## DEVELOPMENT FACILITATION TEAM

### Planning - Case Comments

**Project Number:** PR-2023-009368

**Project Name:** Farolito Senior Community

DRAWING NAME: SITE DEVELOPMENT PLAN

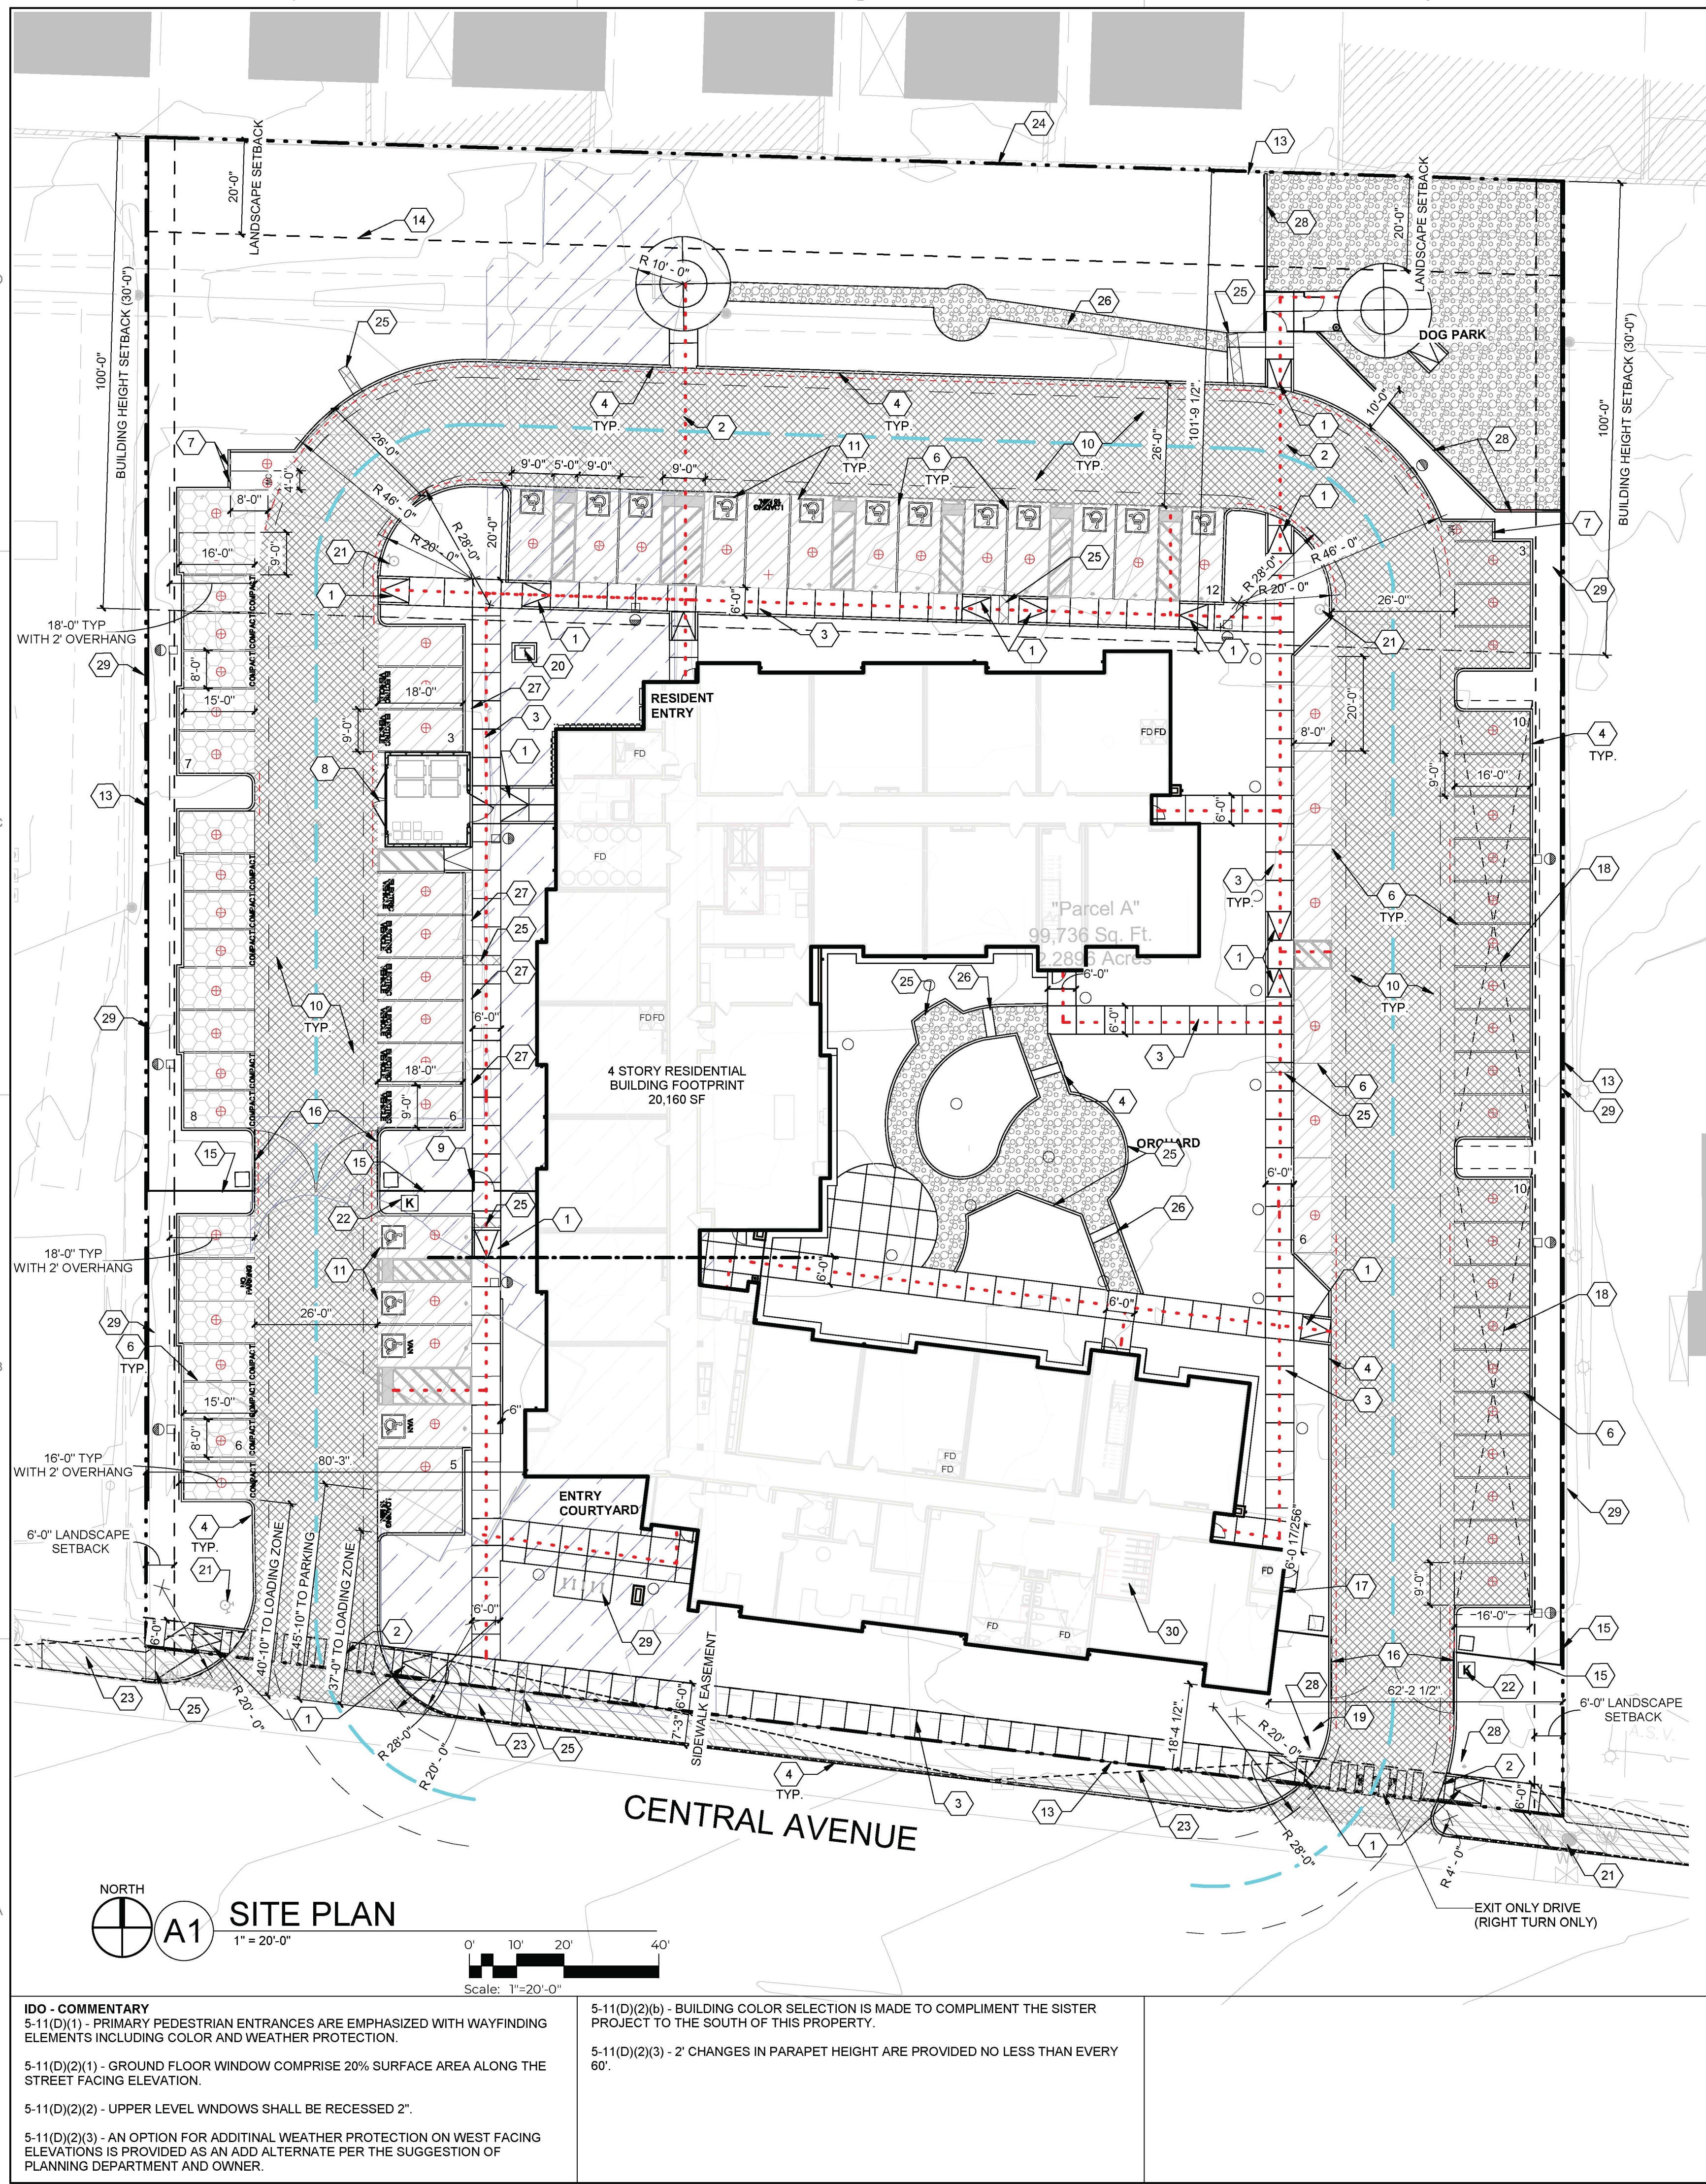
IDO 5-3(D((3)(b) 4. Pedestrian walkways shall be installed along any street-facing façade with a pedestrian entrance of a building containing mixed-use development. Per table 5-3-1 for a building larger than 10,000 sq. ft. and smaller than 50,000 sq. ft. a 10-foot sidewalk is required. Please clarify how design meets this code.

- IDO 5-5(D) requires motorcycle spaces based on required spaces. ~~3 motorcycle spaces should be provided. Please identify and specify motorcycle parking.~~  
 This comment has been addressed
- IDO 5-5(E) requires **bicycle spaces based on provided parking spaces.**  
 Per Table 5-5-5, 3 bicycle spaces or 10% of required off-street parking spaces, whichever is greater is required. 21 Bicycle spaces are required. 36 total bicycle spaces are provided (18 spaces are indoor and 18 spaces are outdoor) **Please verify how many bicycle pads are provided. Only 10 were located on the plan. Please consider showing the indoor bike racks.**  
 There are 10 exterior spaces and 18 interior spaces. The spaces have been noted on the revised site plan.

This development is not mixed-use.

TREE PLANTING DETAIL

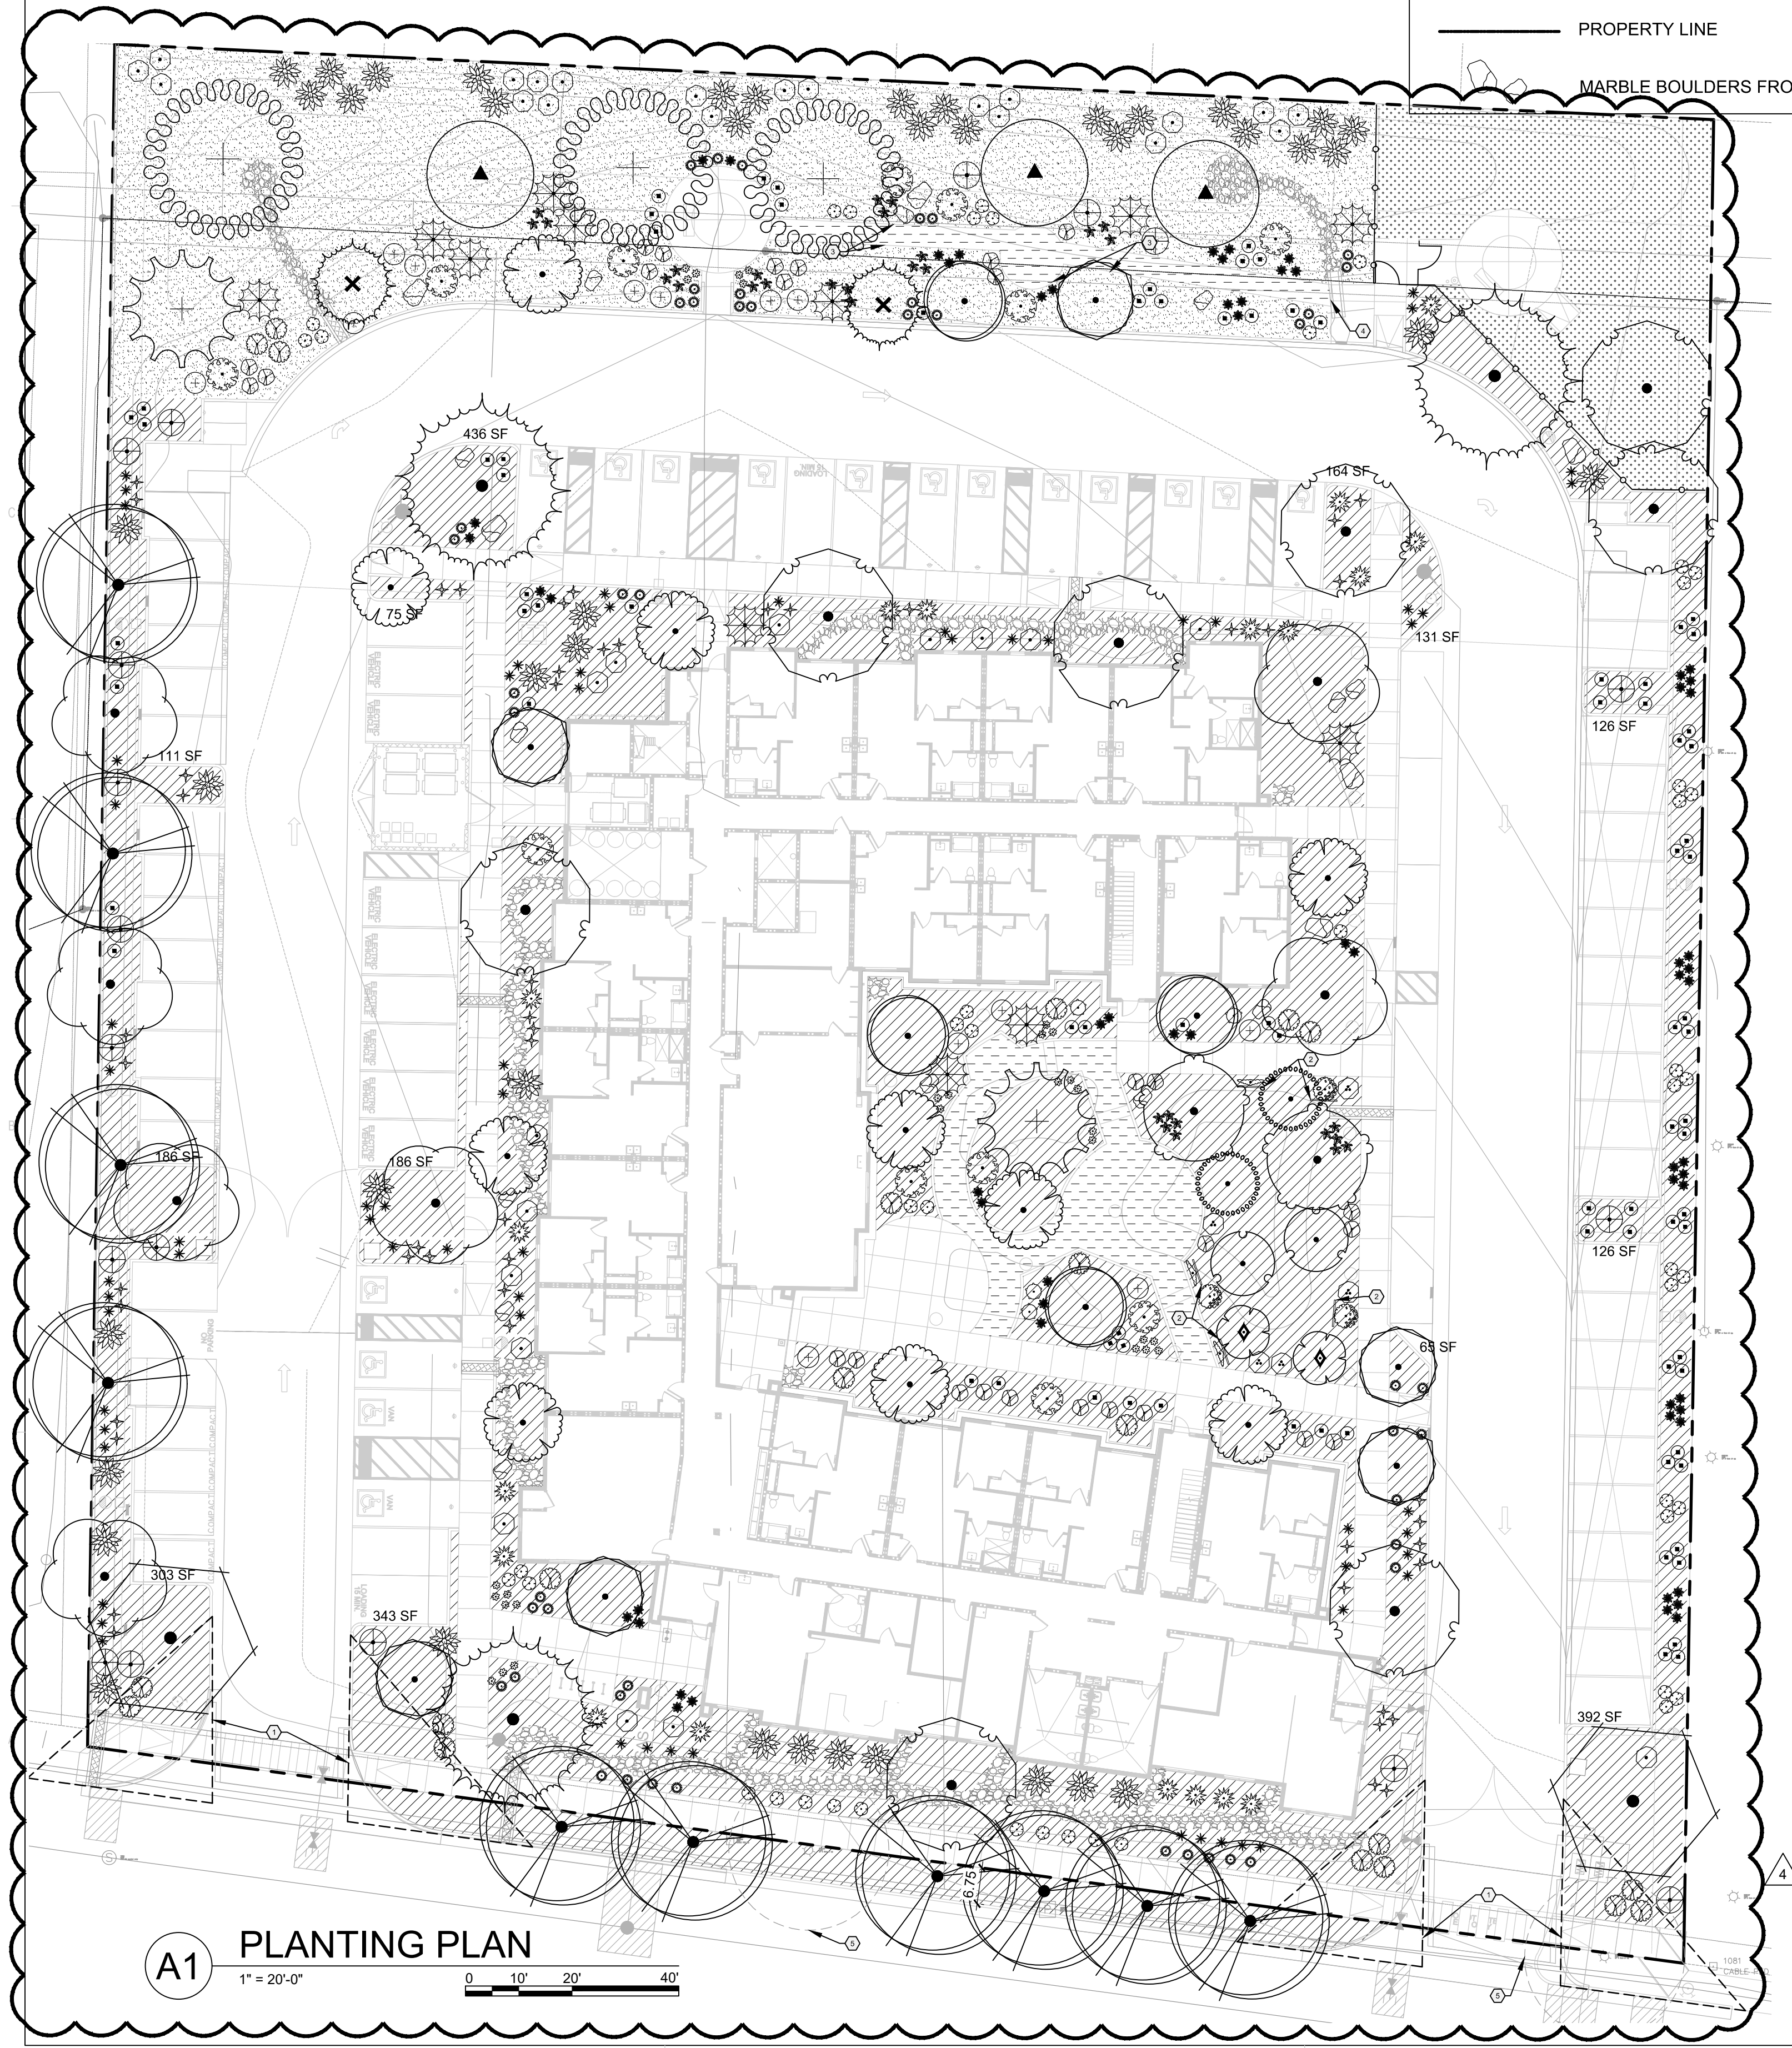
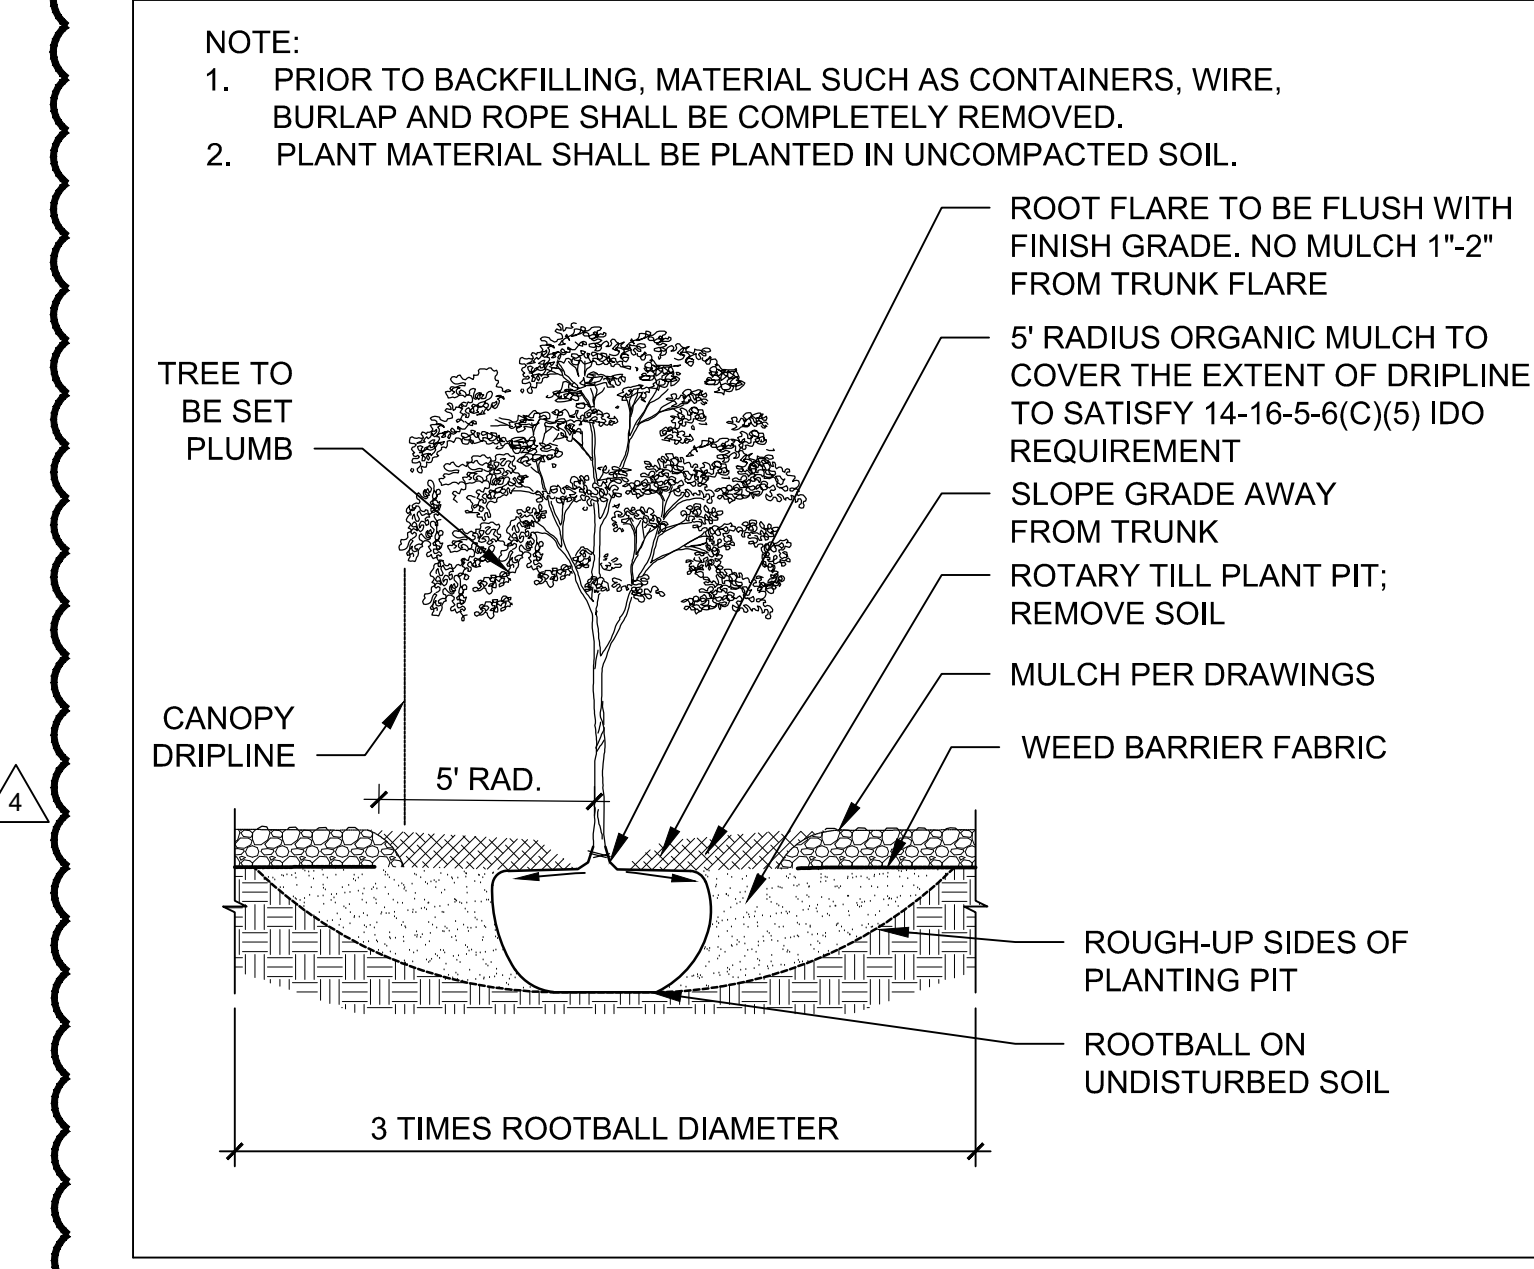
- Per 5-6(C)(5)(e) Organic mulch is required as ground cover under trees within a 5-foot radius around the tree trunk, but not directly against the trunk. In these areas, weed barrier fabric is prohibited. **Please show a 5-foot radius dimension line on the tree planting detail. Please correct the term bark mulch and change it to organic mulch.**

**Addressed, please see updated detail on AS101**

**-Repalce the Raywood ash with Urbanite Ash, Autumn Blaze maple with Bigtooth maple, and Austrian Black pine with Italian Stone pine.** Addressed-DPS.

**-Change the trees under the overhead distribution line along the north edge of the project to Golden rain trees and Russian hawthorns.** Addressed, planting was arranged to meet new plant sizes.

**-Of the two different locust trees you have proposed, choose one type only and spread them in the site so no two locust trees are adjacent to one another, because of the appearance of the beetle that has been killing locust trees.** Addressed, all Locusts are now Purple Robe Locusts, none are next to each other- DPS.

**-Please be aware that Purple Robe locust requires structural pruning. Also, fruit trees are prone to frost damage (especially fig trees). Please add a comment to reflect that if any of the proposed trees die off at any time, they will be replaced with new ones.**  
**-If you have any questions regarding these comments, please contact Bonnie Strange, Senior Planner at the Urban Forestry at [bstrange@cabq.gov](mailto:bstrange@cabq.gov).**

A general note was added to address the locusts, as for the fruit trees, this client specifically requested an orchard on the property for their residents. They have prepared for the proper care and maintenance required. -DPS
